PLANNING APPLICATION CONSULTATION RESPONSE

Application Number:	3/2023/0858
Proposal:	Retention of wedding marquee and raised decking to the west of the main built form of Stanley House until 31.12.2027.
Location:	Stanley House Preston New Road Mellor BB2 7NP

Objection 1 – Inadequate Surface Water Sustainable Drainage Strategy

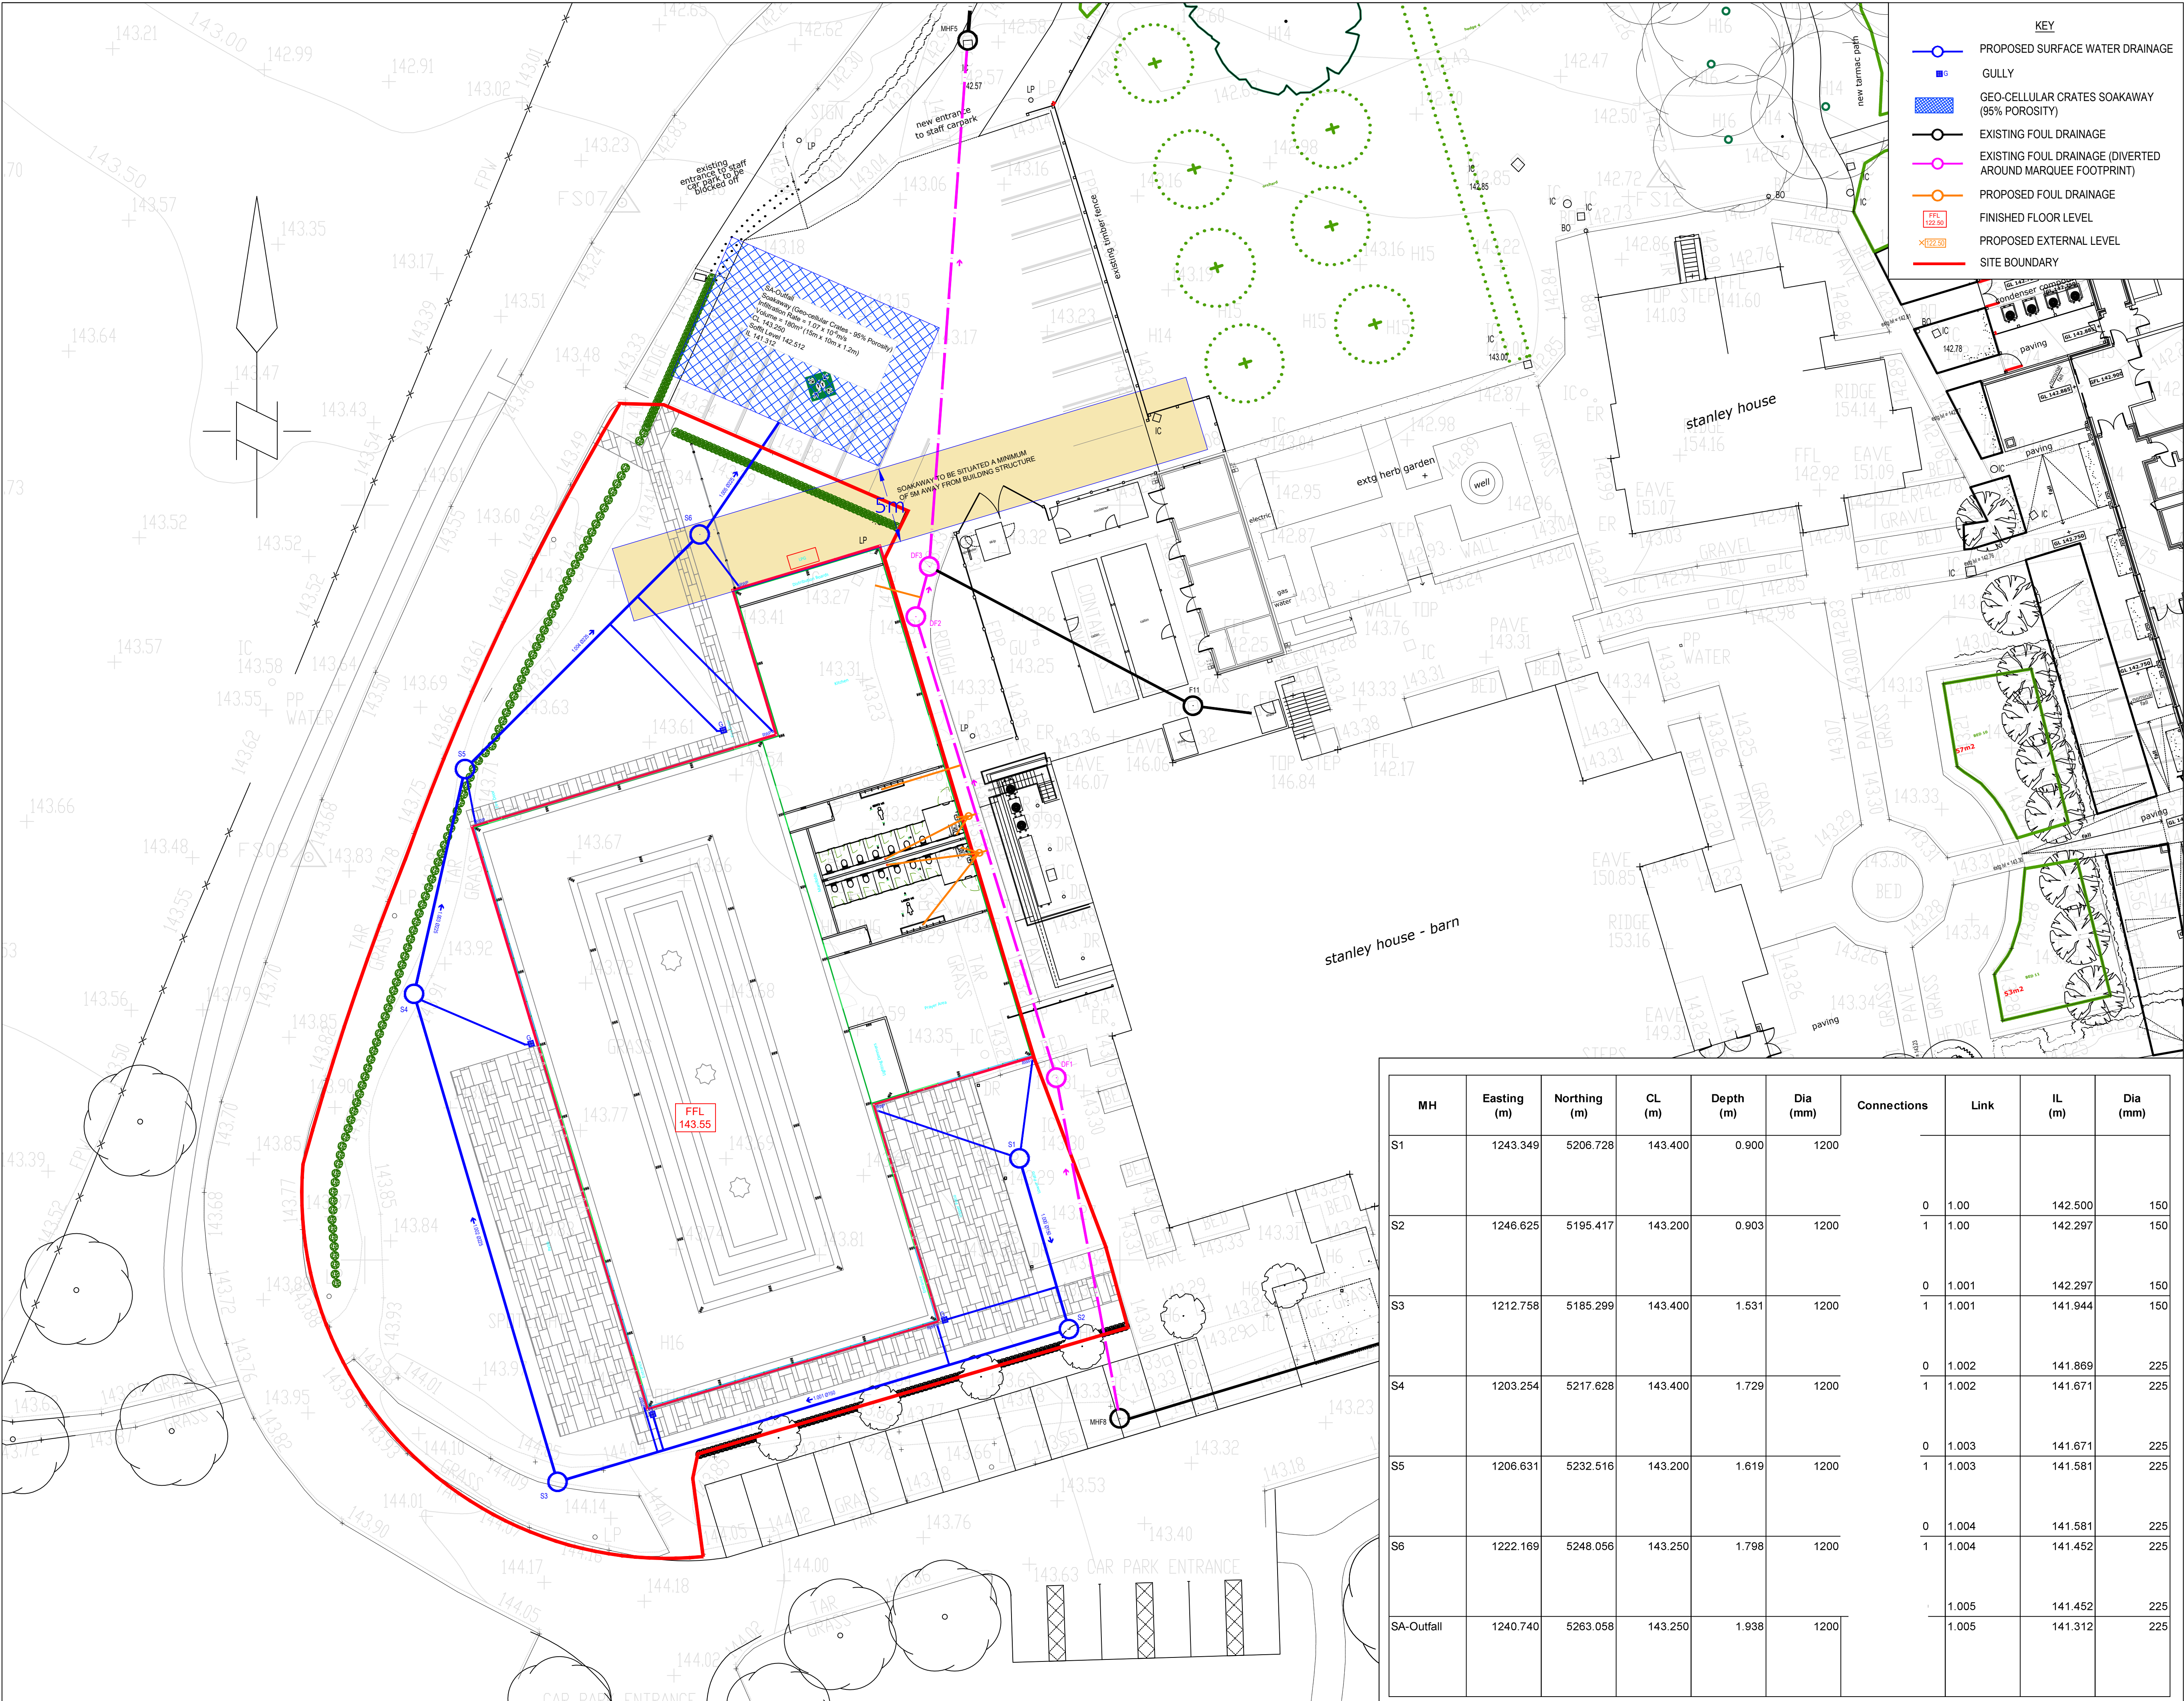
- In particular, the submitted surface water sustainable drainage strategy fails to provide evidence how the temporary marquee area is being drained and the method of this isn't causing an undue flood risk.

Although the applicant has provided information relating to proposed drainage plans through the redevelopment of the site, this does not satisfy the requirements for evidence relating to the drainage of the temporary marquee area, as this needs to be managed appropriately until such time as the redevelopment is complete and the new proposed drainage system has been put in place.

You can overcome our objection by submitting information that covers the deficiencies highlighted above and demonstrates how surface water will be managed on-site, to satisfy Paragraphs 173 and 175 of the National Planning Policy Framework, the Planning Practice Guidance, and the Defra Technical Standards for Sustainable Drainage Systems. If this cannot be achieved we are likely to maintain our objection to the application. Production of this information will not in itself result in the removal of an objection.
